Our ref: WX/2019/133441/01-L12
Your ref: TRO40011

Date: 16 February 2020

**METROWEST PHASE 1 DEVELOPMENT CONSENT ORDER APPLICATION
EXAMINATION DEADLINE 5 - EXAMINING AUTHORITY'S FURTHER WRITTEN
QUESTIONS AND REQUESTS FOR INFORMATION (EXQ2)**

Figure N-23: Pre Development, 20year return period event in 2115 ,Tidal

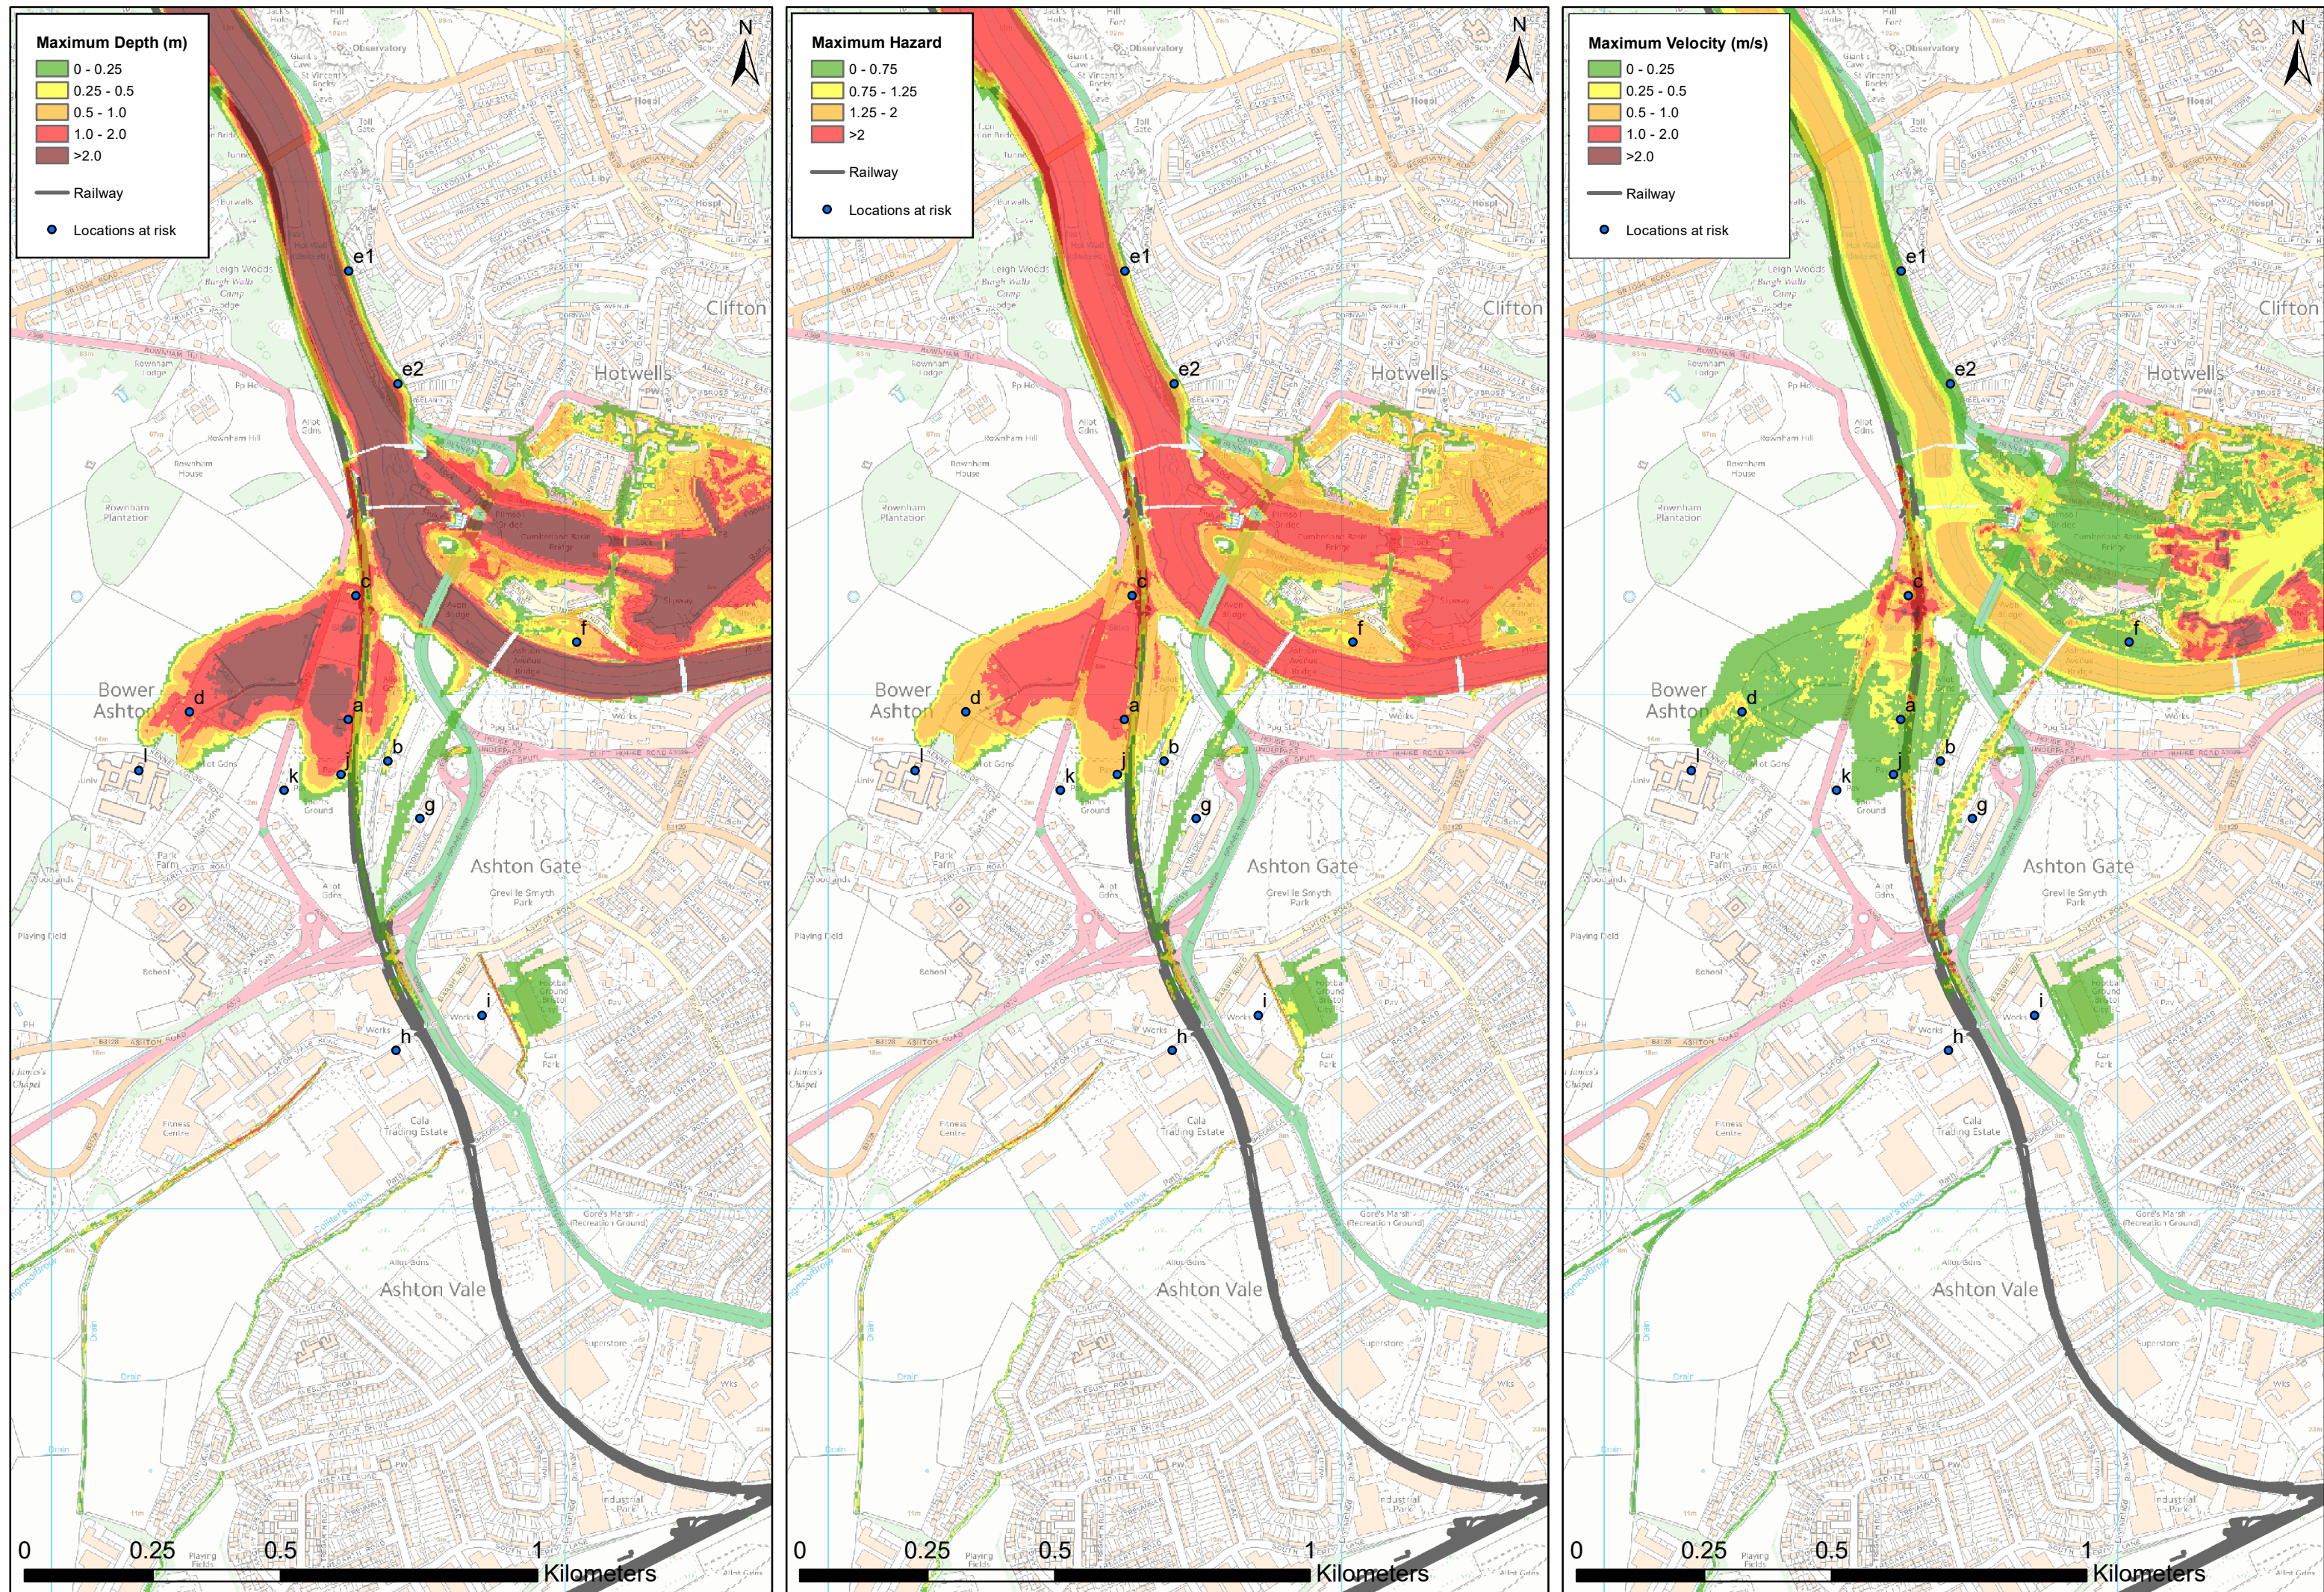
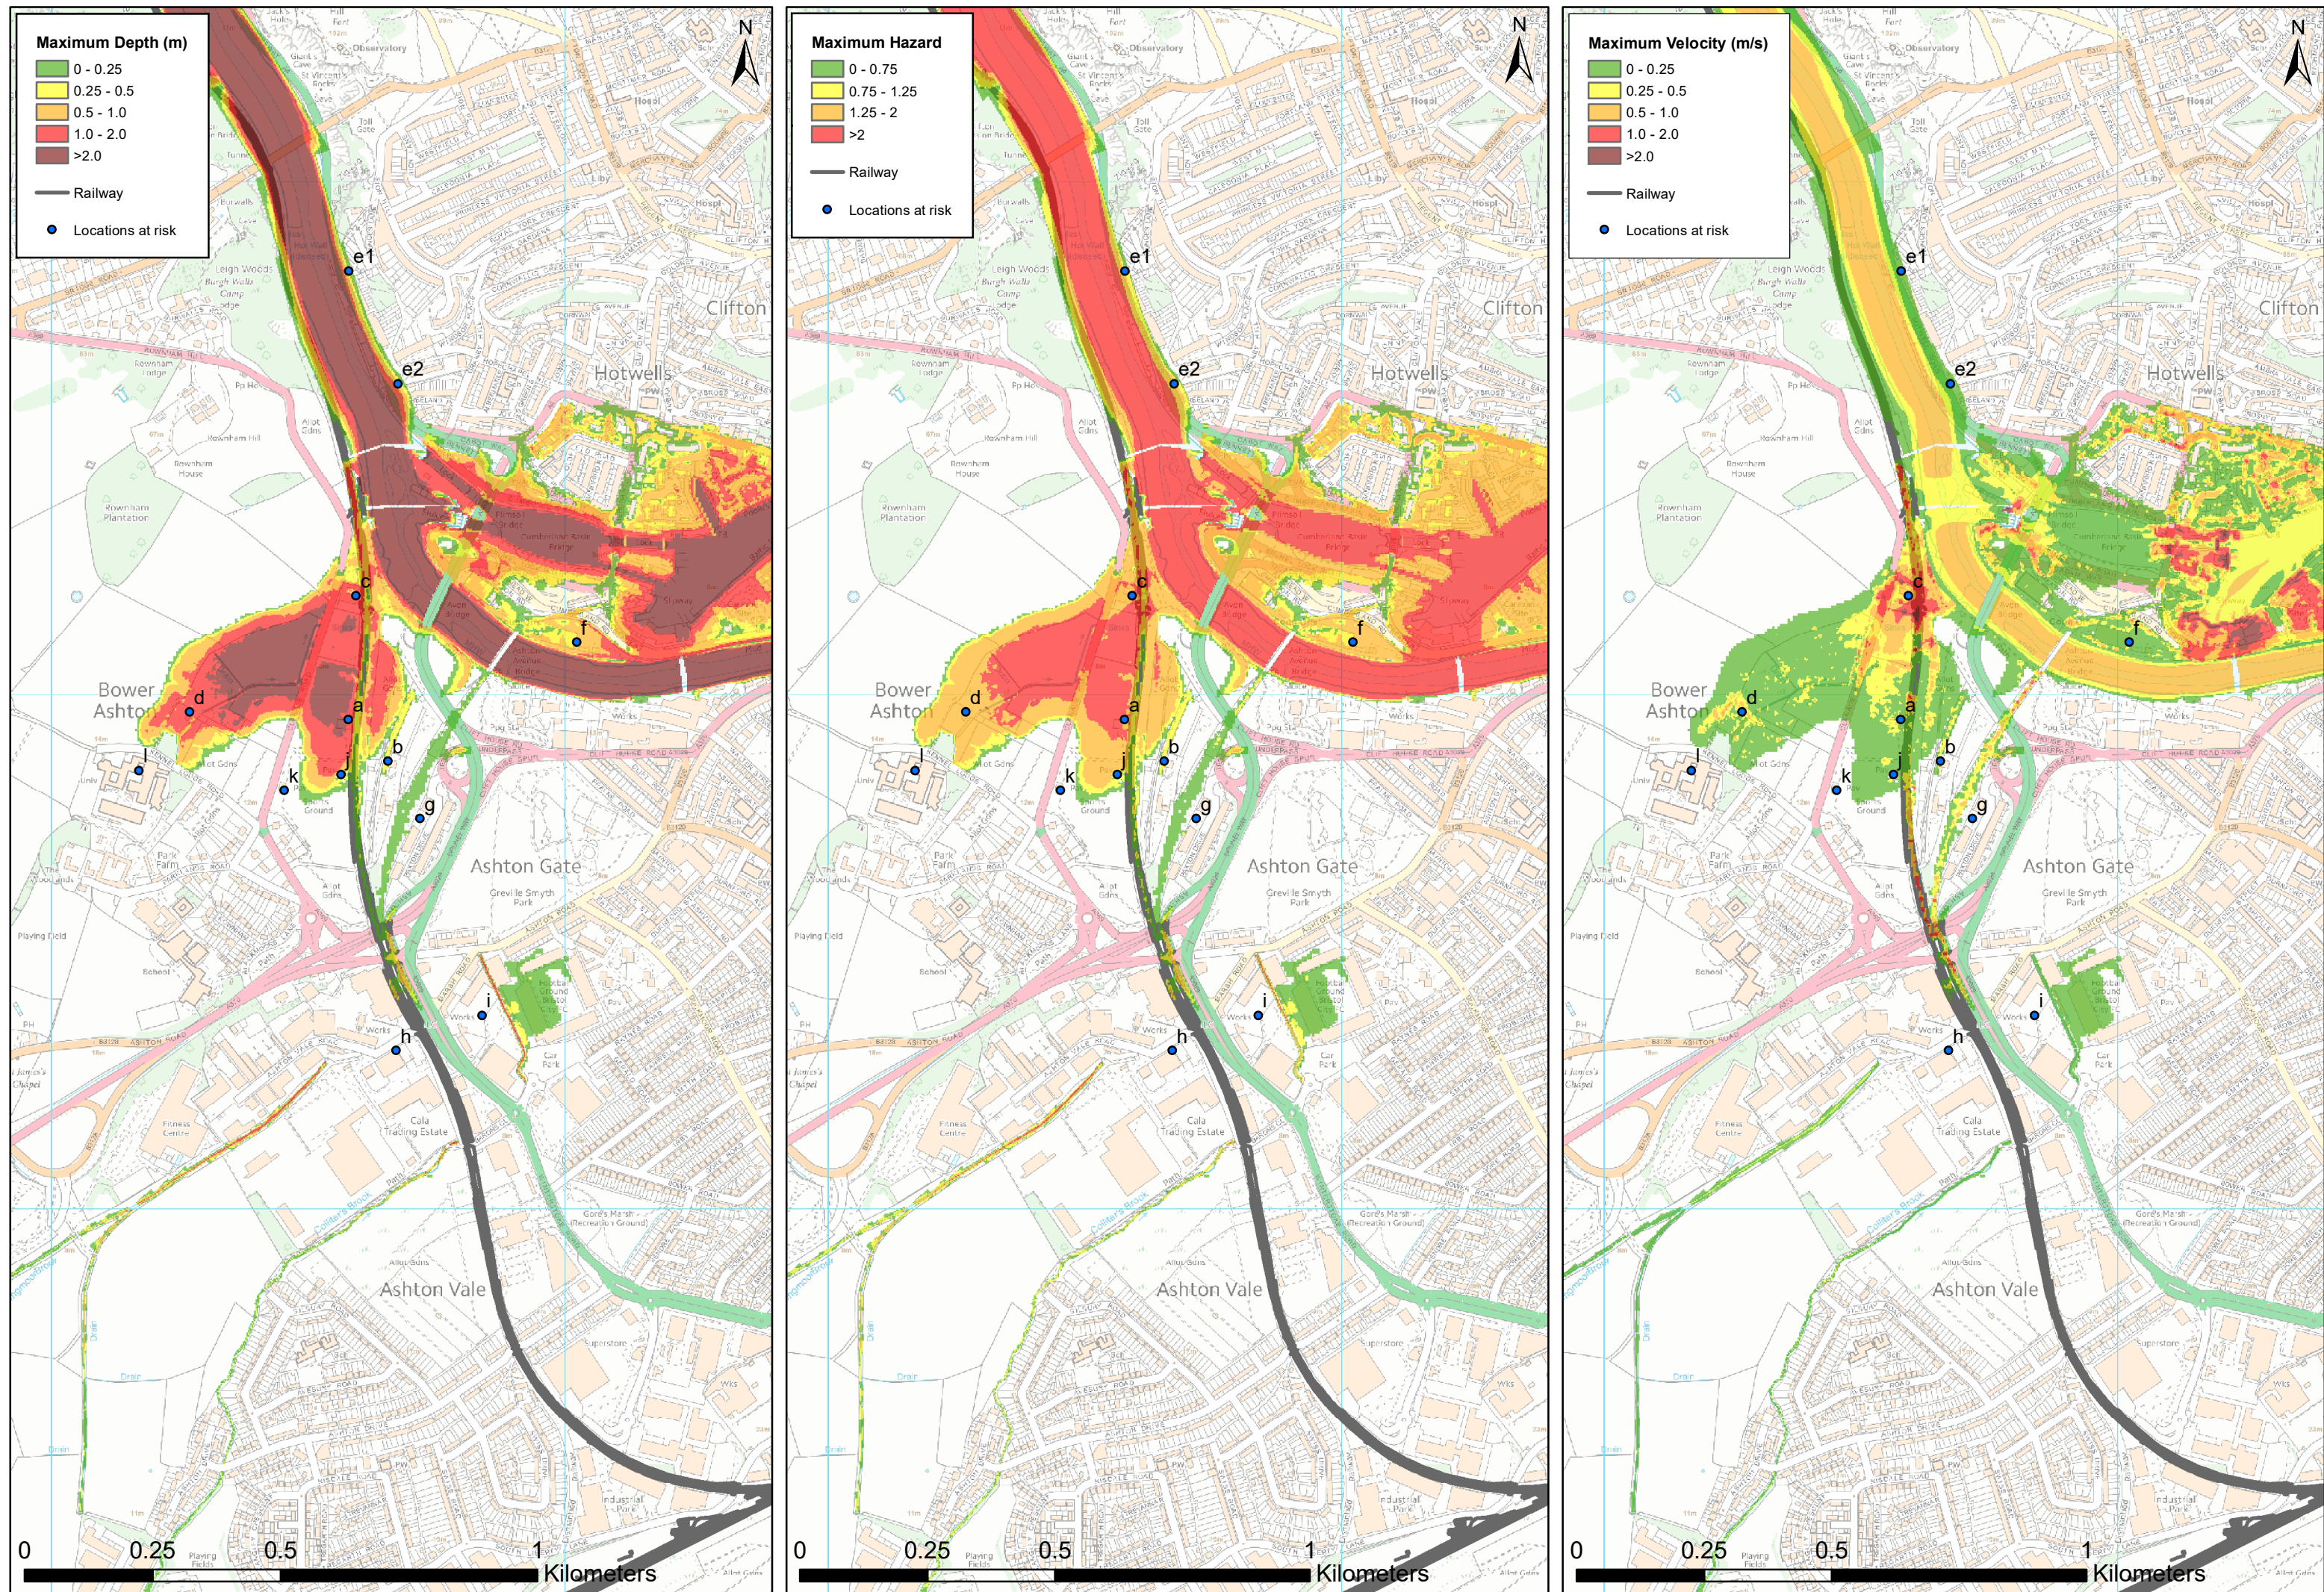
The applicant's model, based on the CAFRA model and made site specific by improving the ground elevation data within the model, was run for a tidal and fluvial combination, based on the FD2308 joint probability calculation spreadsheet. The condition set out in the model to represent a 1 in 20 year tidal event is a 20 year tidal design boundary return period, combined with a mean annual flow. See table 2 hereunder, extracted from Appendix N part 1 page 11

When the model is run with the above condition, it predicts 0.53 m of flooding of the railway at Bower Ashton and Clanage Road. The photos taken on the 12 March 2020 shows some flooding on the site. The Agency is surprised by the applicant's contention that the model is over-predicting flooding to that extent. The model was calibrated, and the applicant made it more site specific by adding topographic information. The model was also reviewed and validated by the Agency's National Evidence and Risk team.

The Agency would therefore contend that the 12 march 2020 event was not a 1 in 20 event, which would explain why no flooding was observed at Bower Ashton/Clanage Road on the 12 March 2020. Accordingly, the Agency must disagree with the applicant's contention that the model is over-predicting flooding.
